APPROVED
Limited building only review
Permit holder responsible for full compliance with the code

75 SECRETARIAT Circle
SAWFORD, NC

FRONT PORCH
 HS SECRETARIAT Circle
 SAFFORD, D.C.

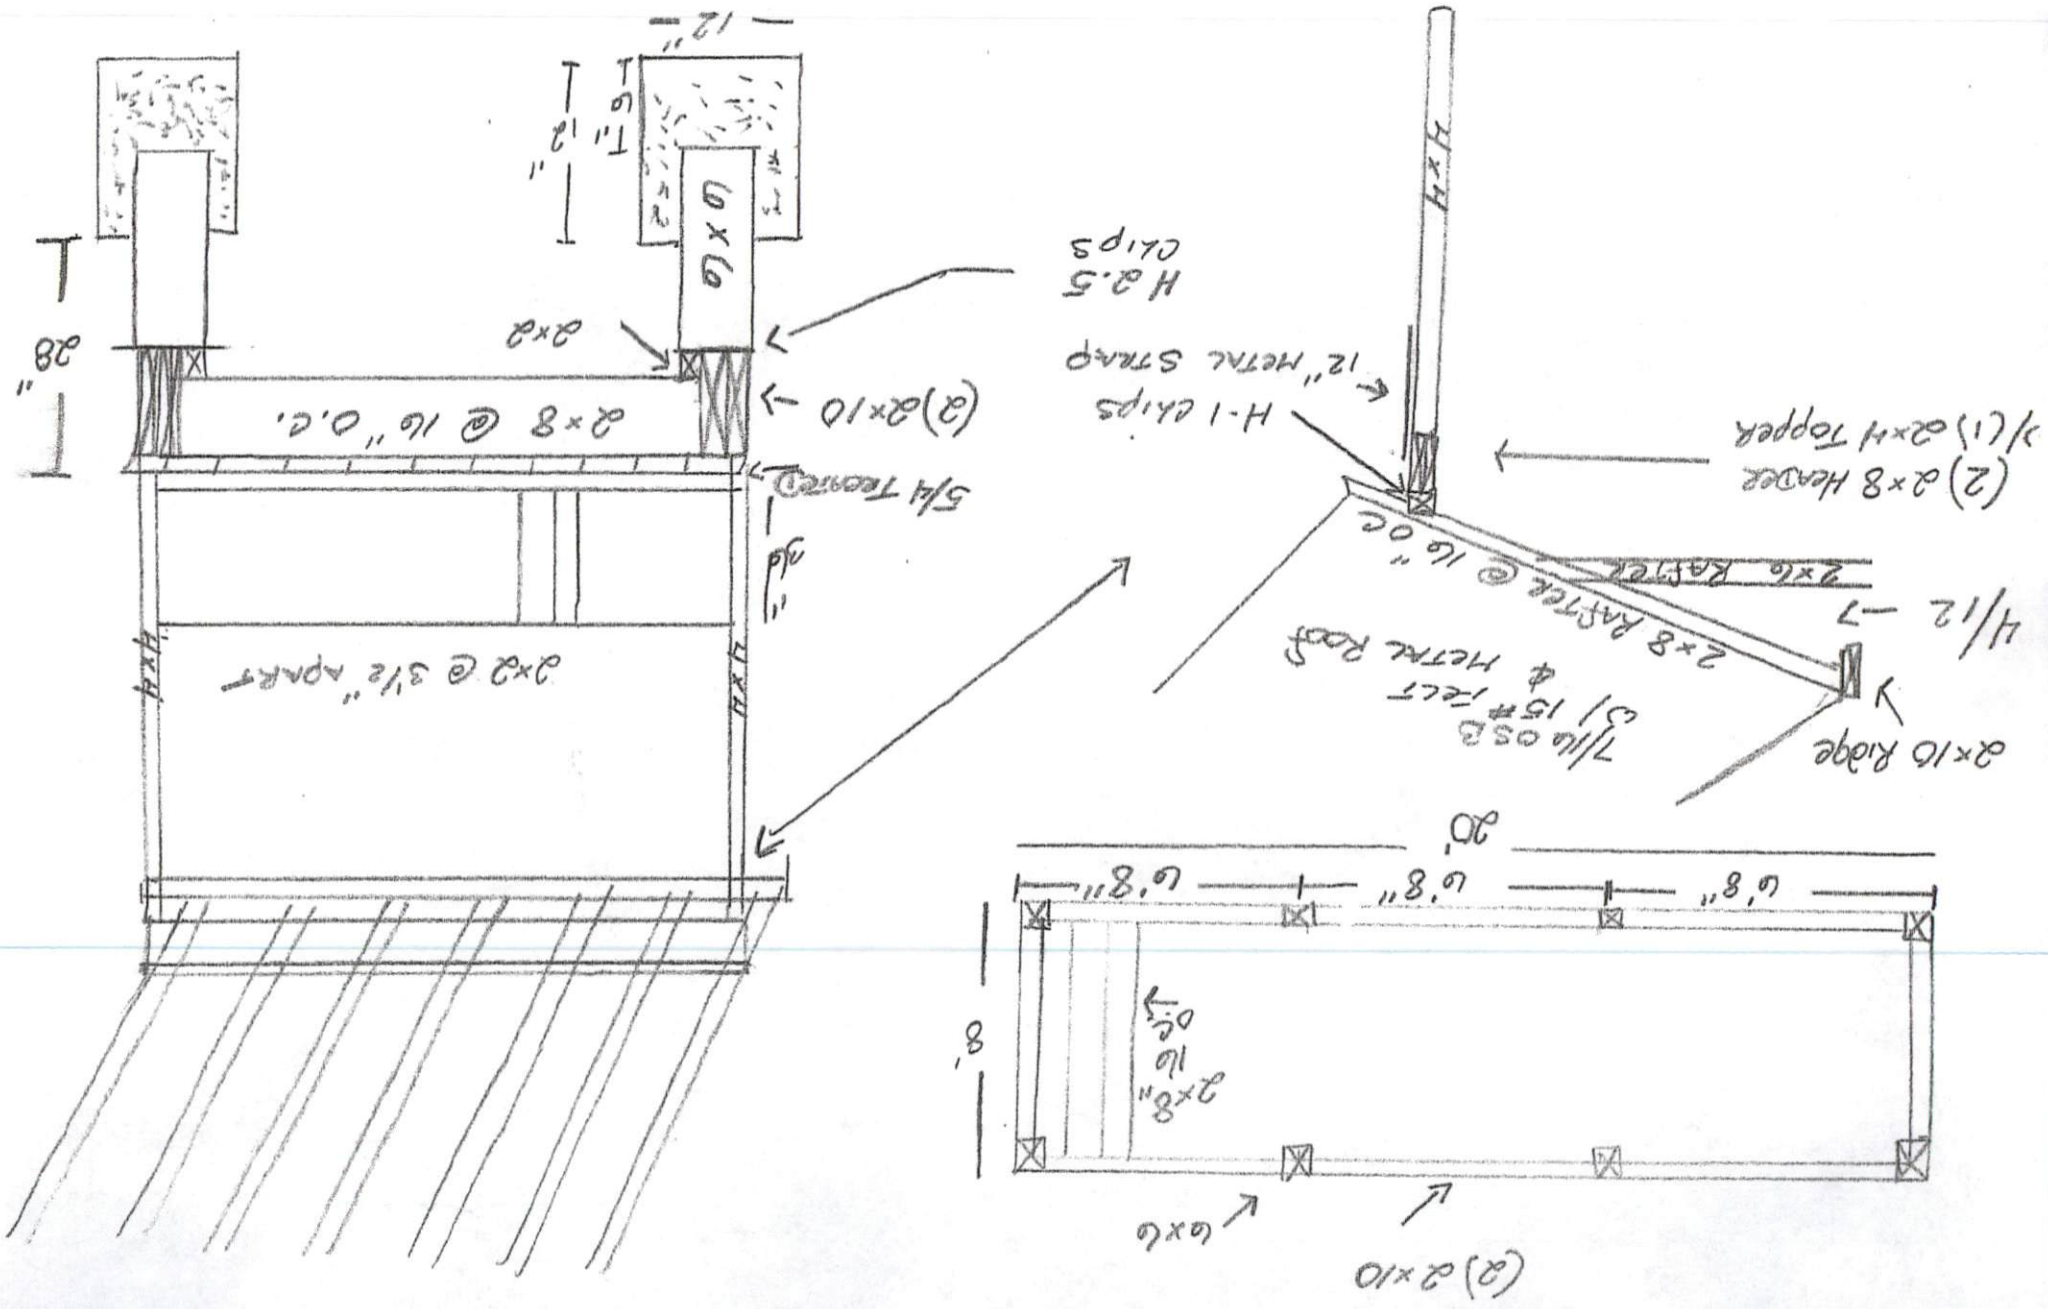
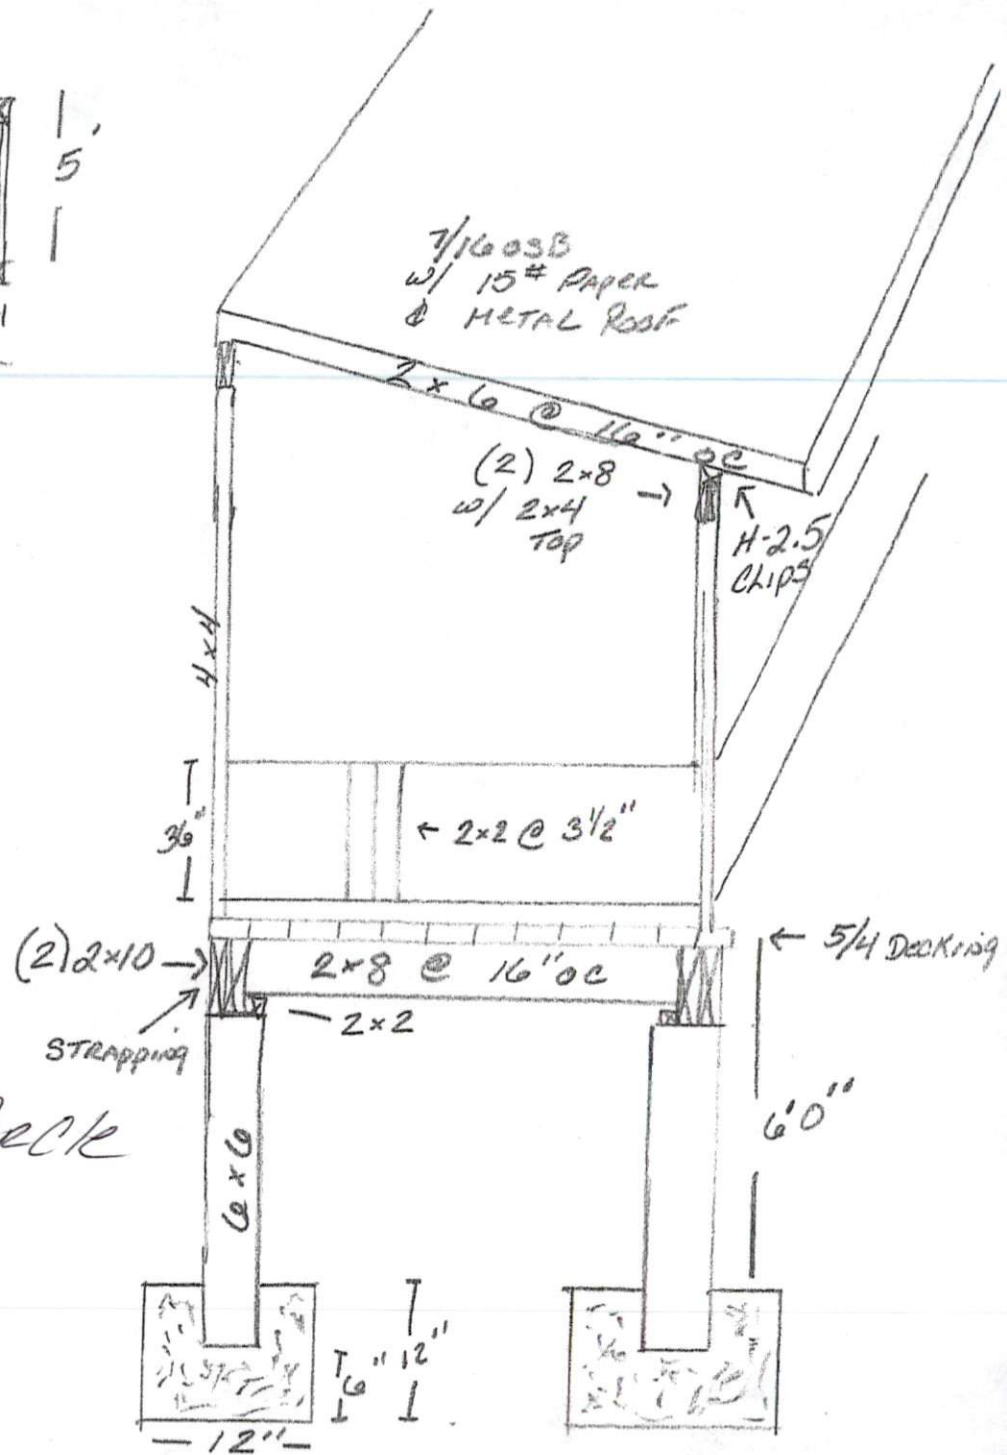
See notes for front porch.

2-2x10 Min. for 8 ft span

Ceiling joists must be min 2x8 16" oc and located in the lower 1/3 of the rafter span.
